From: Contact Centre (CRM) <contact@ribblevalley.gov.uk>
Sent: 24 March 2026 12:37
To: Planning
Subject: Planning Application Comments - 3/2026/0021 FS-Case-817244874

Planning Application Reference No.: 3/2026/0021

Address of Development: Flat, 41-43 Wellgate Clitheroe BB7 1LU

SHEET:  
Proposed Ground and First  
floorplan

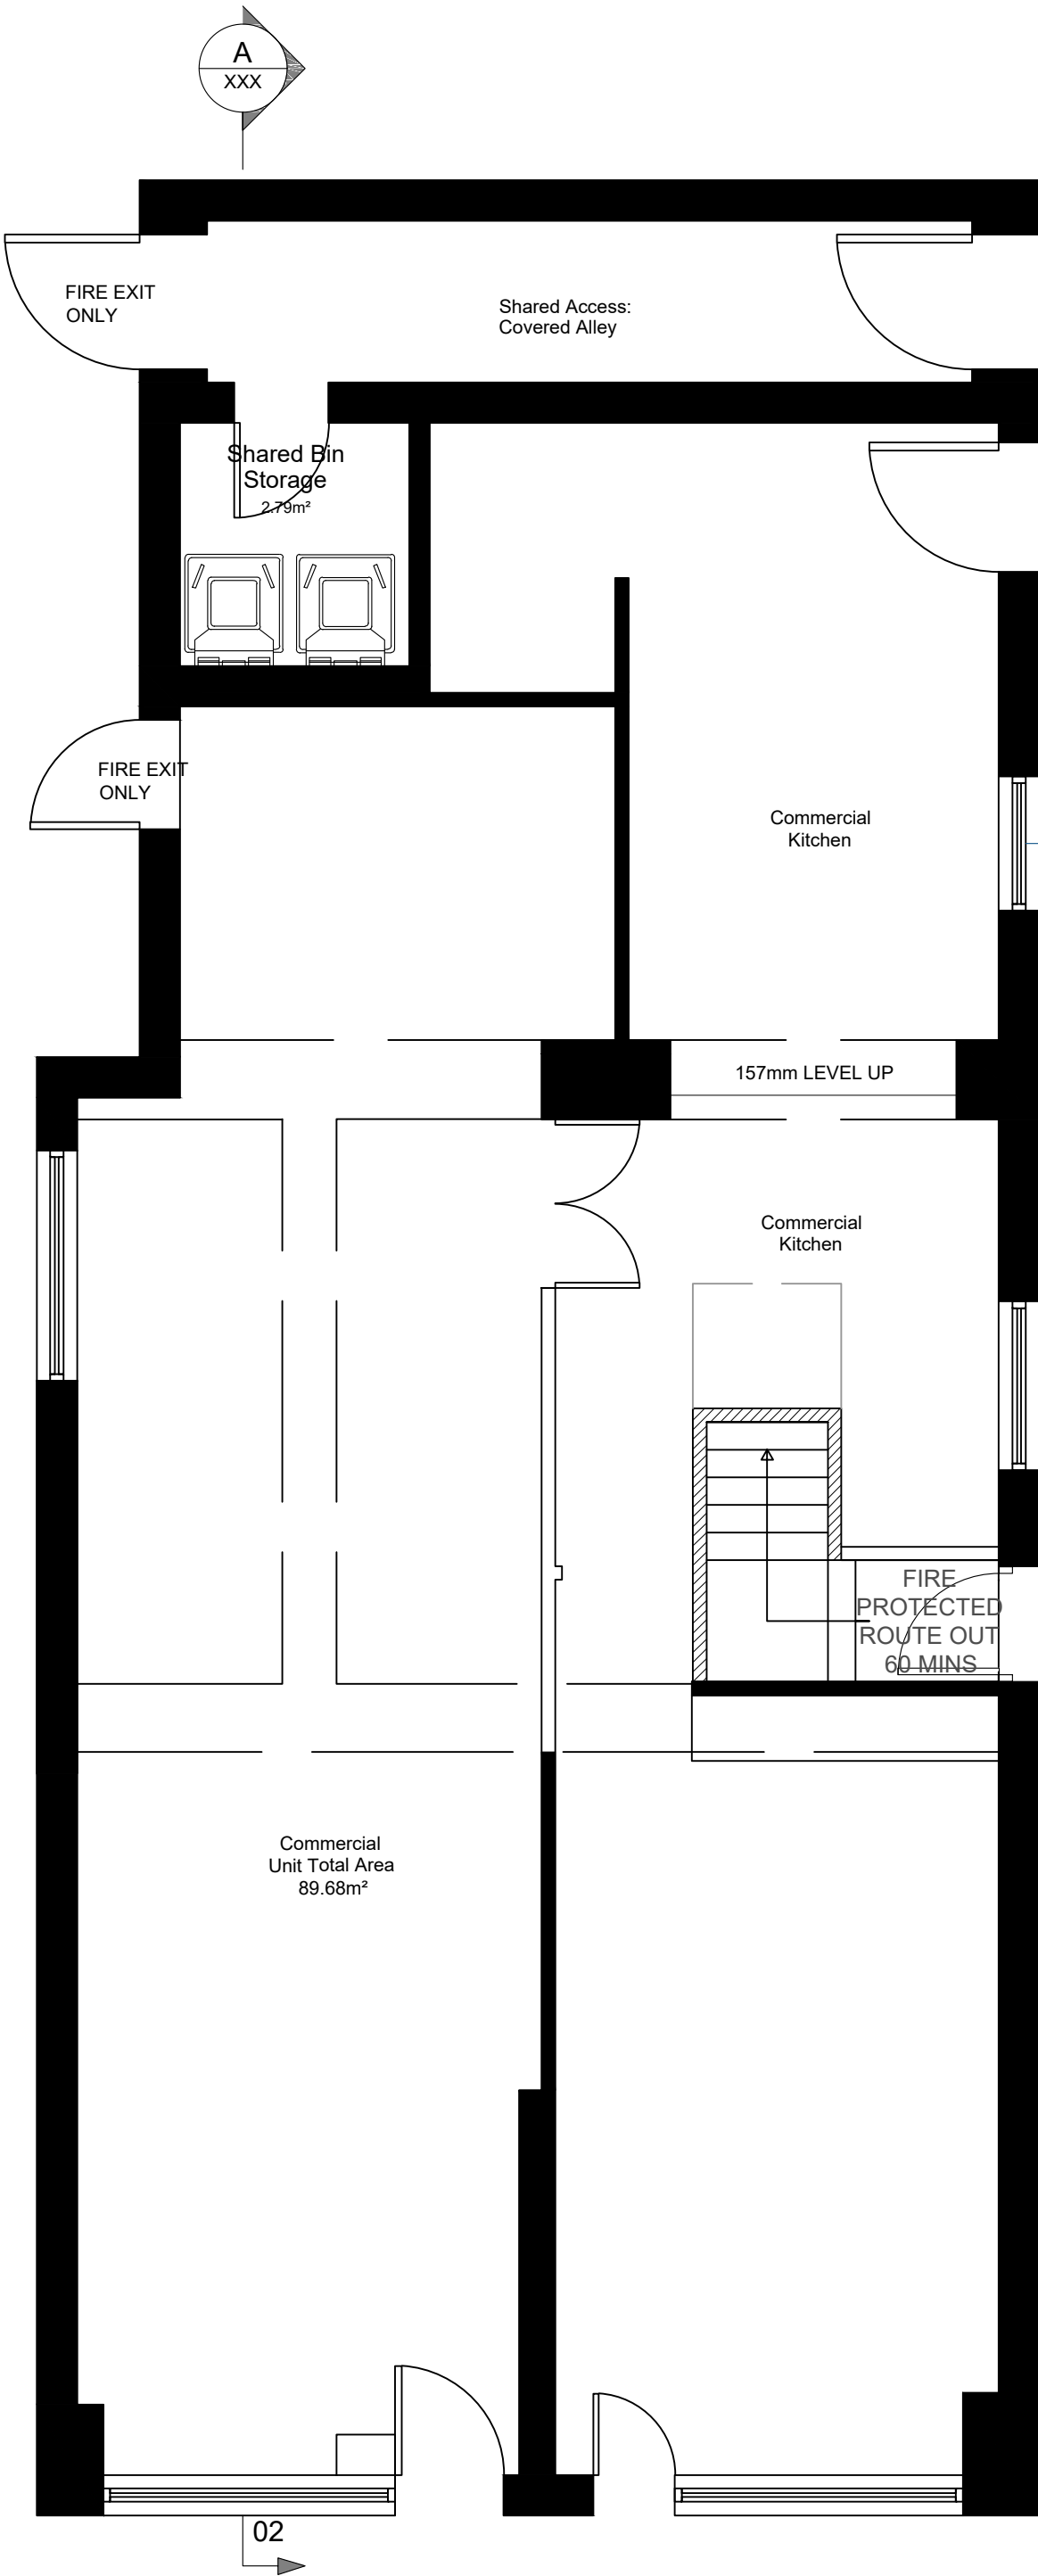
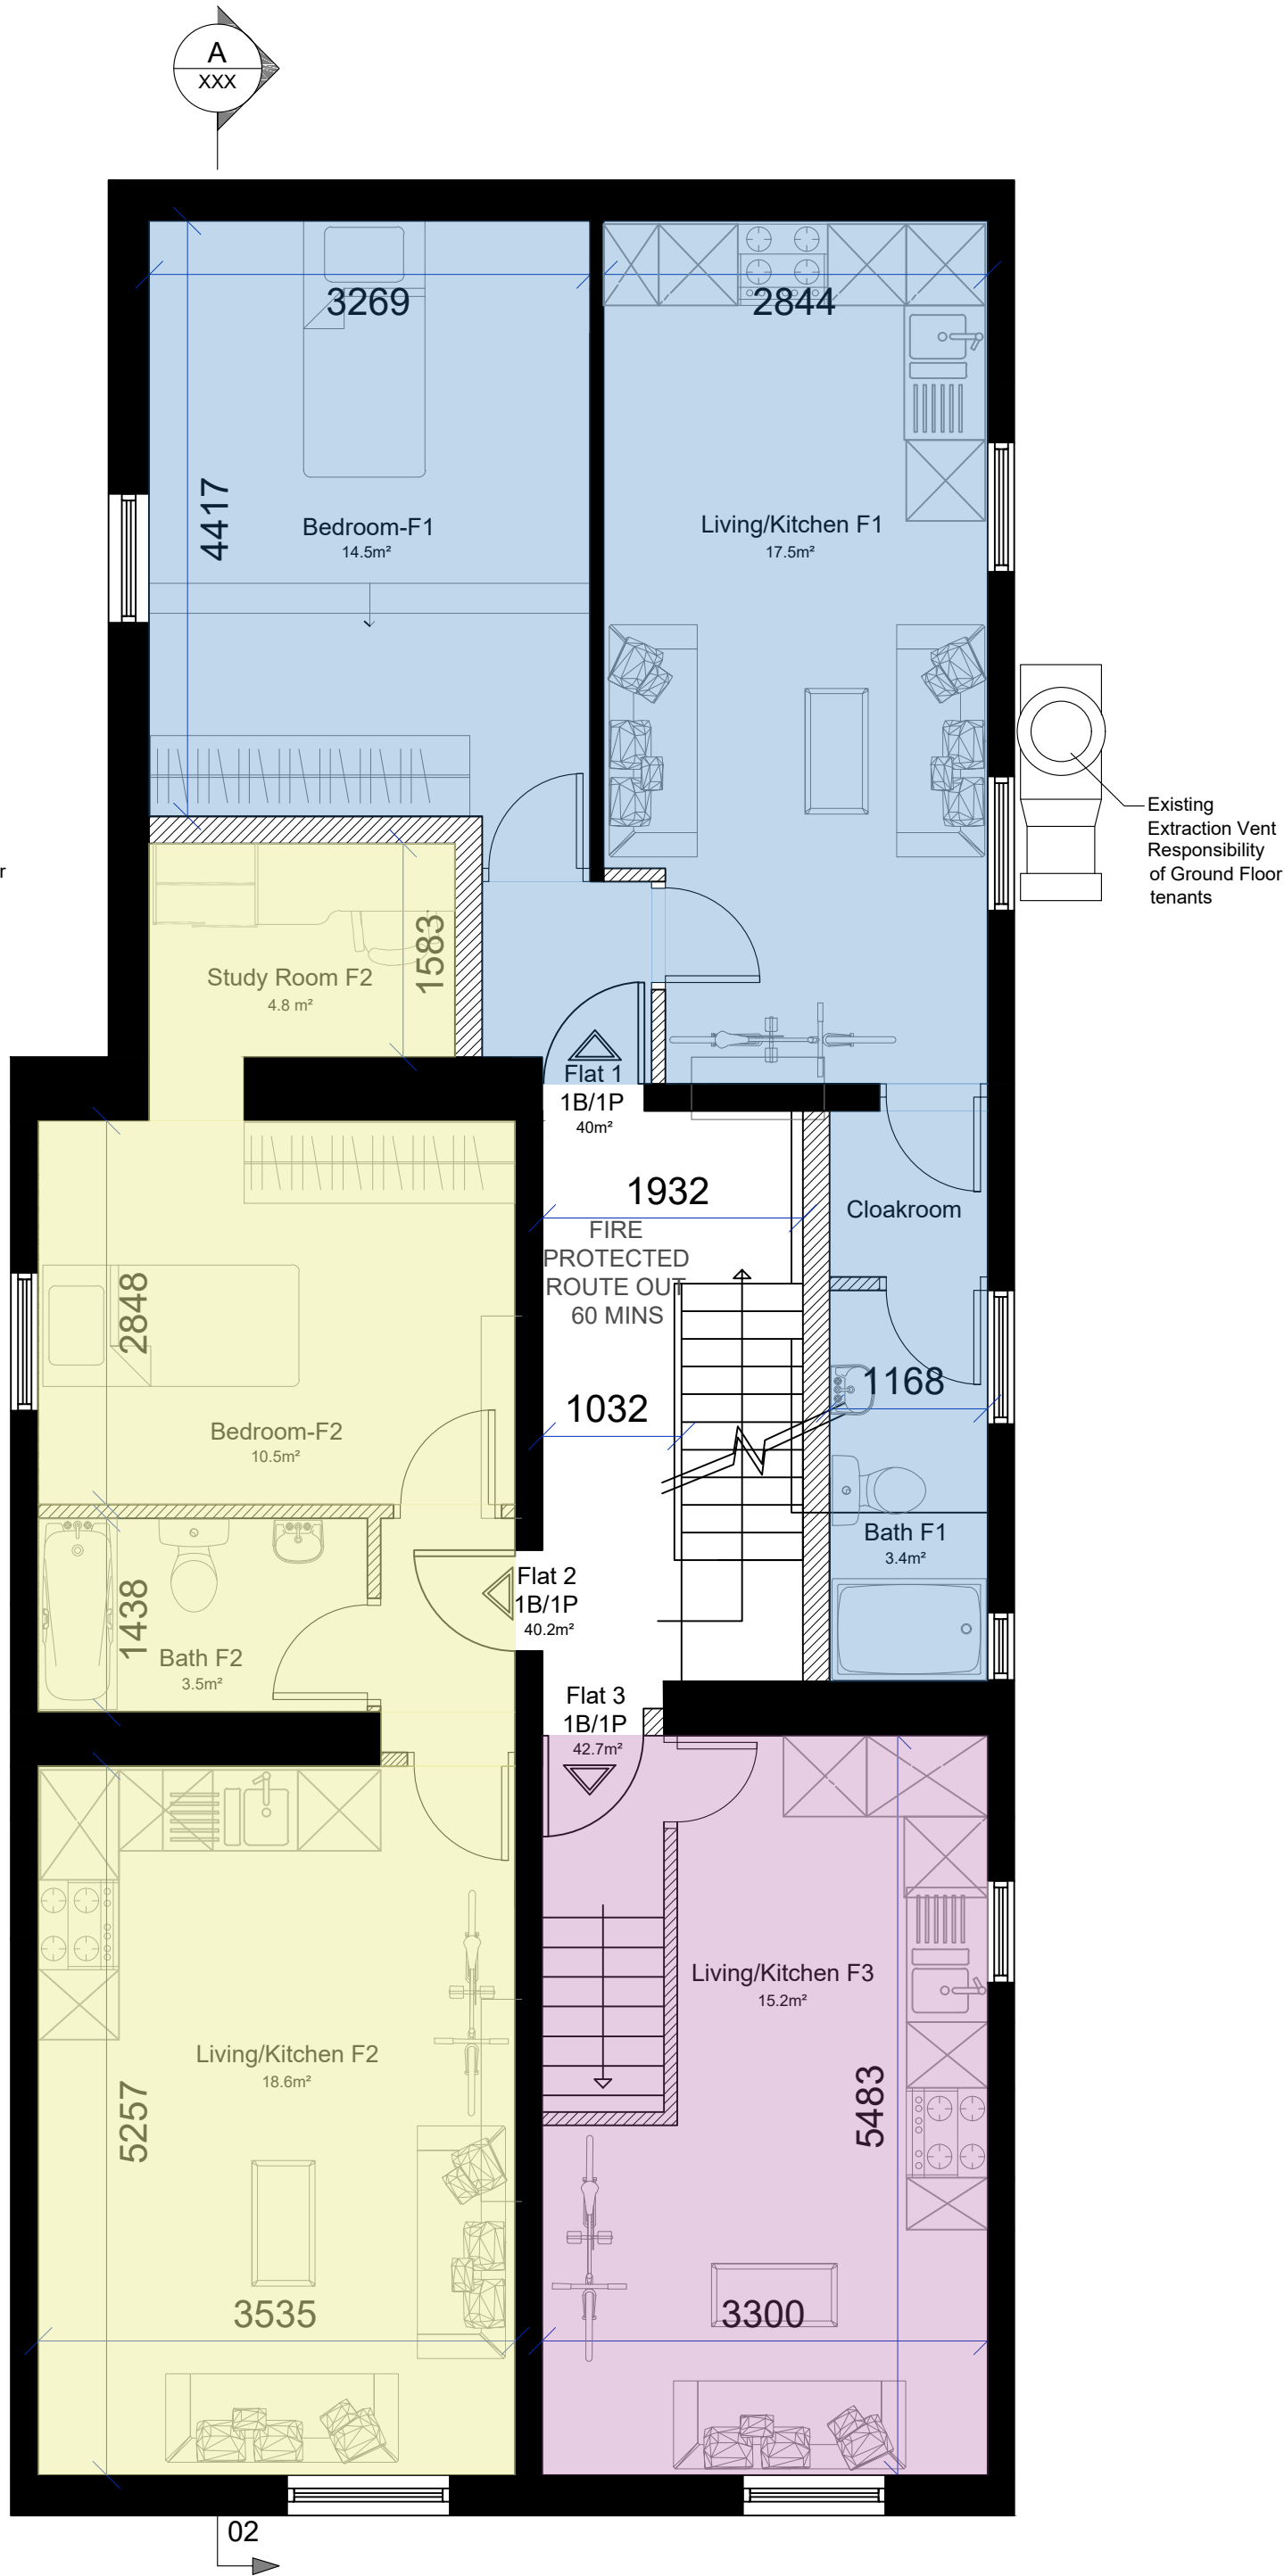
Point 2 I do not find the refuse situation suggested as being adequate, in the bin store the plan shows 2 wheely bins, which is not enough for 4 flats, when you consider what Ribble valley refuse policy says

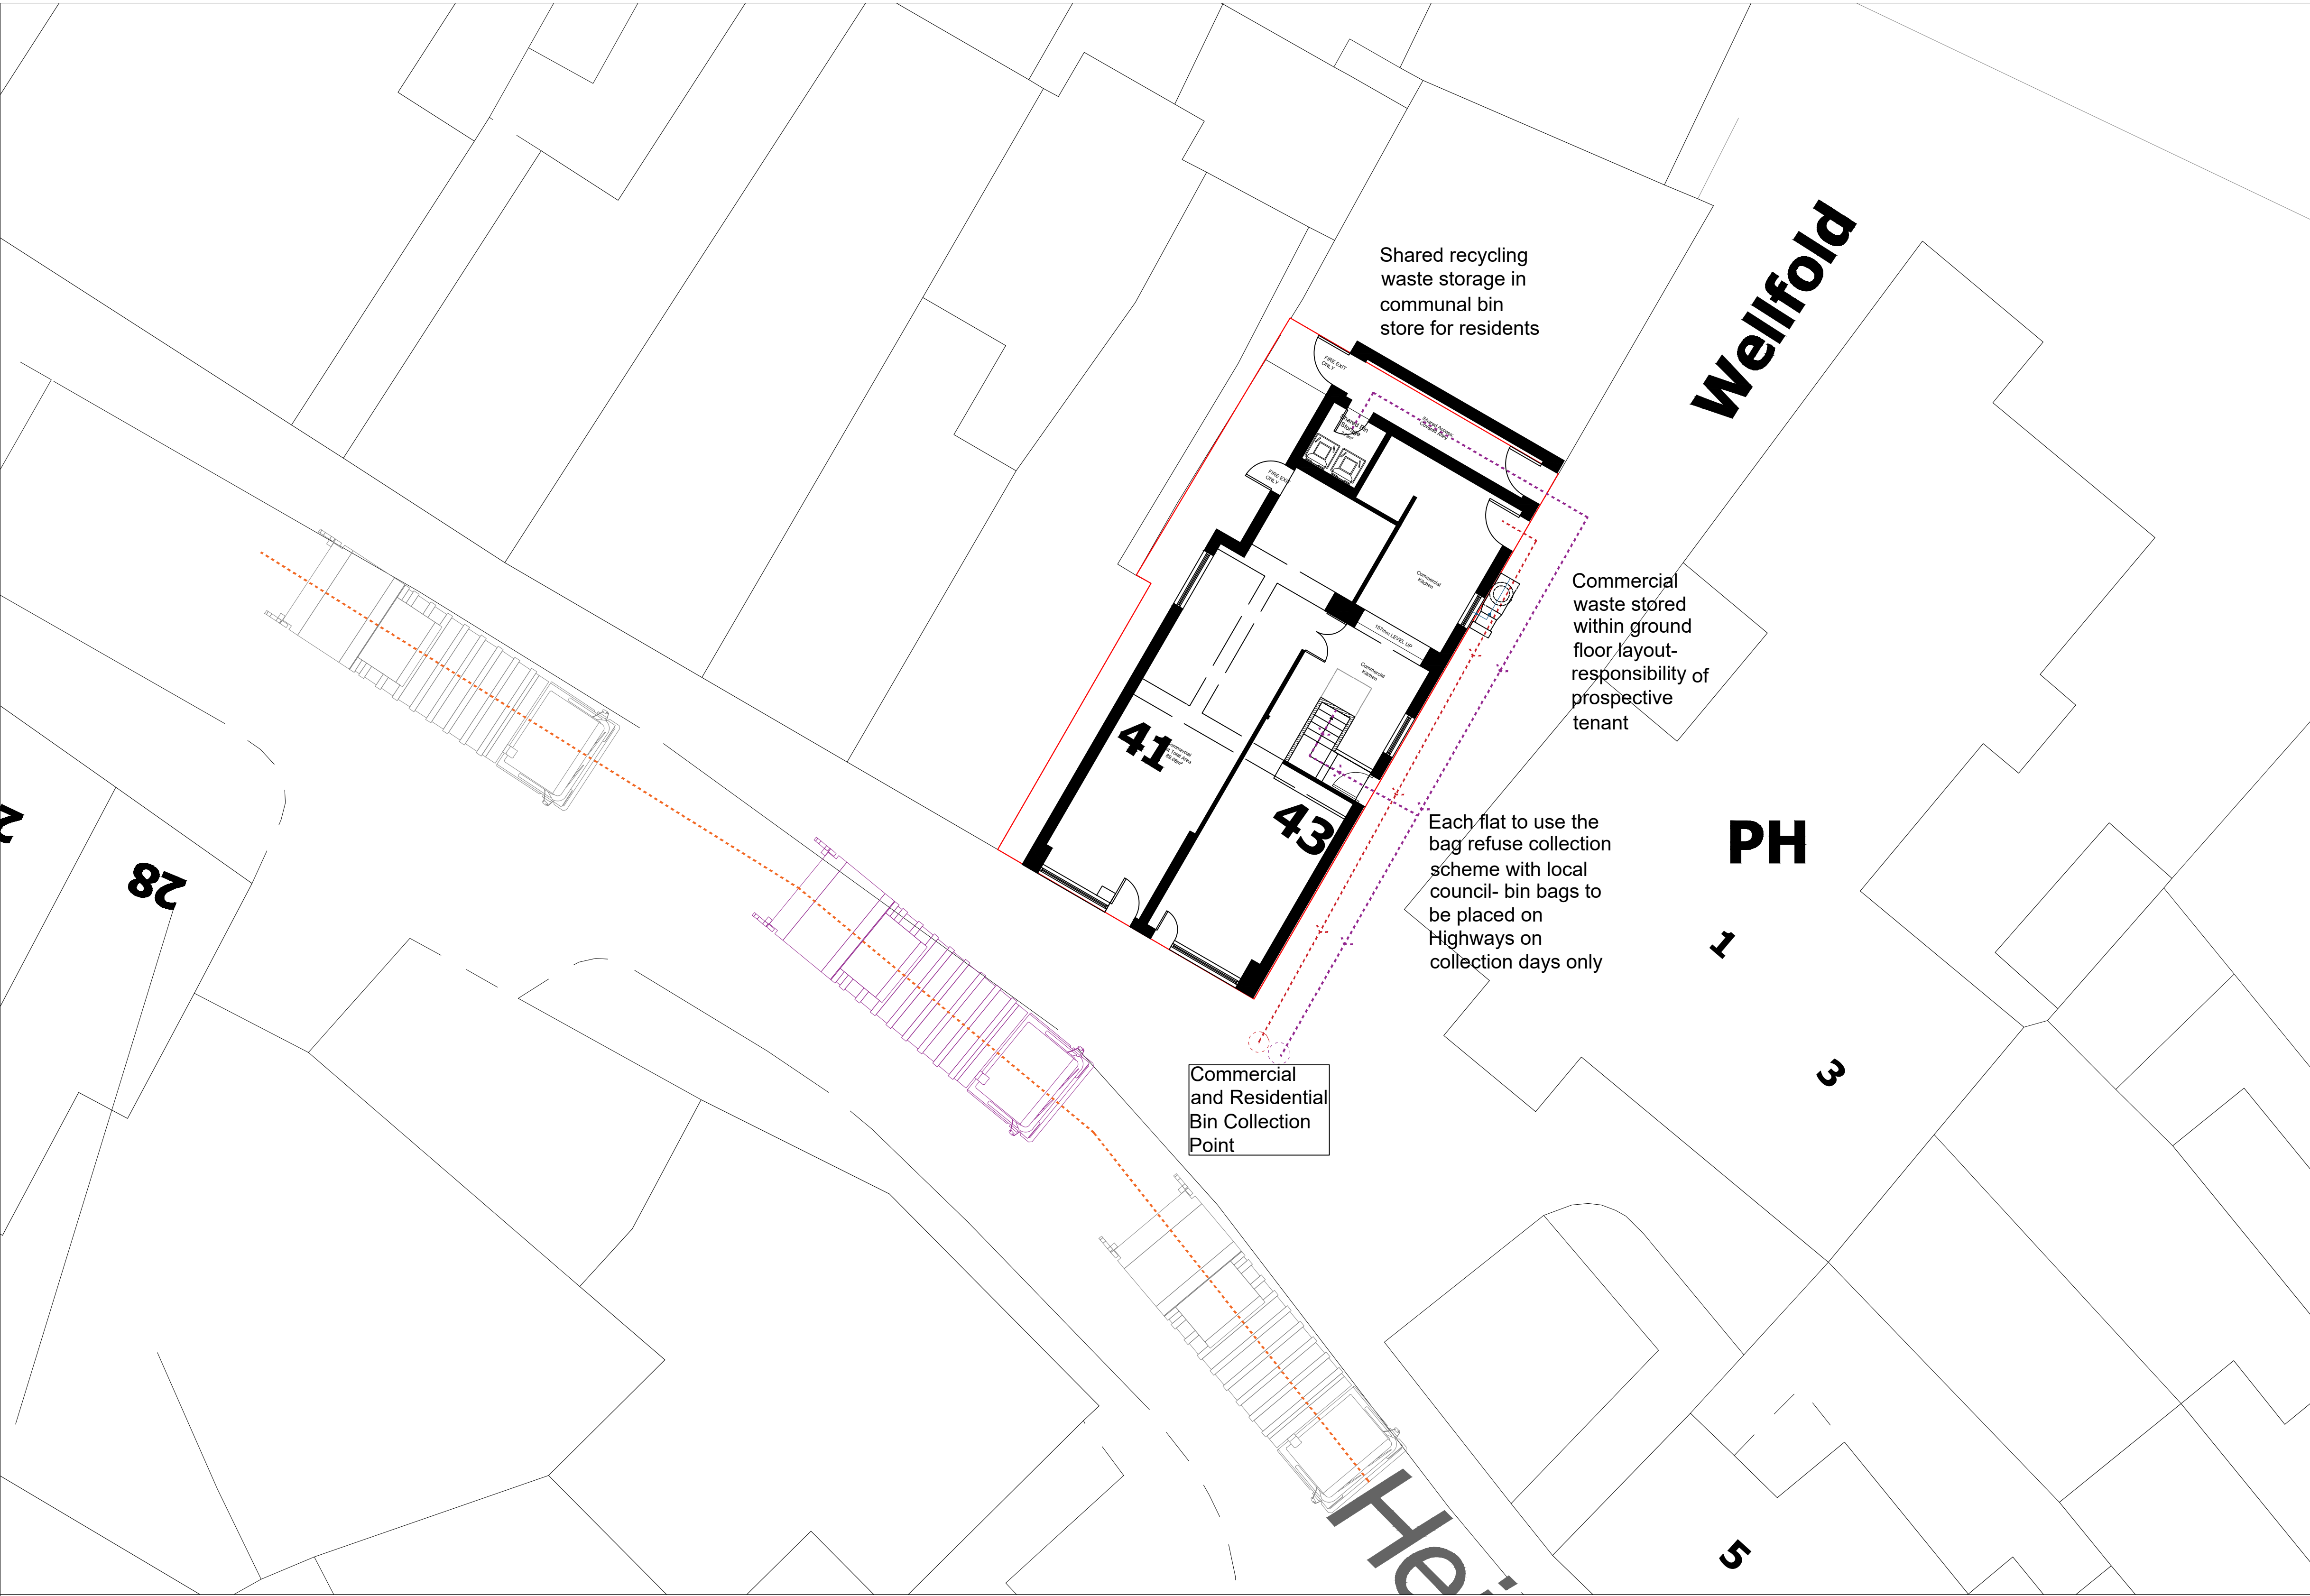
Ribble Valley Borough Council is introducing a new mandatory weekly food waste recycling service starting in April 2026. Where is that to go?

The plan then says "Each flat to use the bag refuse collection scheme with local council- bin bags to be placed on Highways on collection days only"

I am concerned that if it is bags they will be out on Wellgate at the front of the Dog Inn from the night before collection day they will not be against a wall so will be at the mercy of the weather, vermin never mind the public on a night out. The ginnel between 43 Wellgate and the Dog Inn is at best messy and at worst a tip I don't think putting rubbish bags at the side of the road will improve that, in fact I can only see it being made worse. It is a busy walkway to and from Tesco and Holden Street carpark and is one of the gateways into Clitheroe.

You may say that the bags will only go out on the day of collection, in the real world they will go out the night before.

The refuse storage for the ground floor retail is listed as “Commercial waste stored within ground floor layout responsibility of prospective tenant”, I have concern that this will in fact be another large wheeled skip left out in the ginnel and it should be a condition that no skips or bins to left out other than collection day.
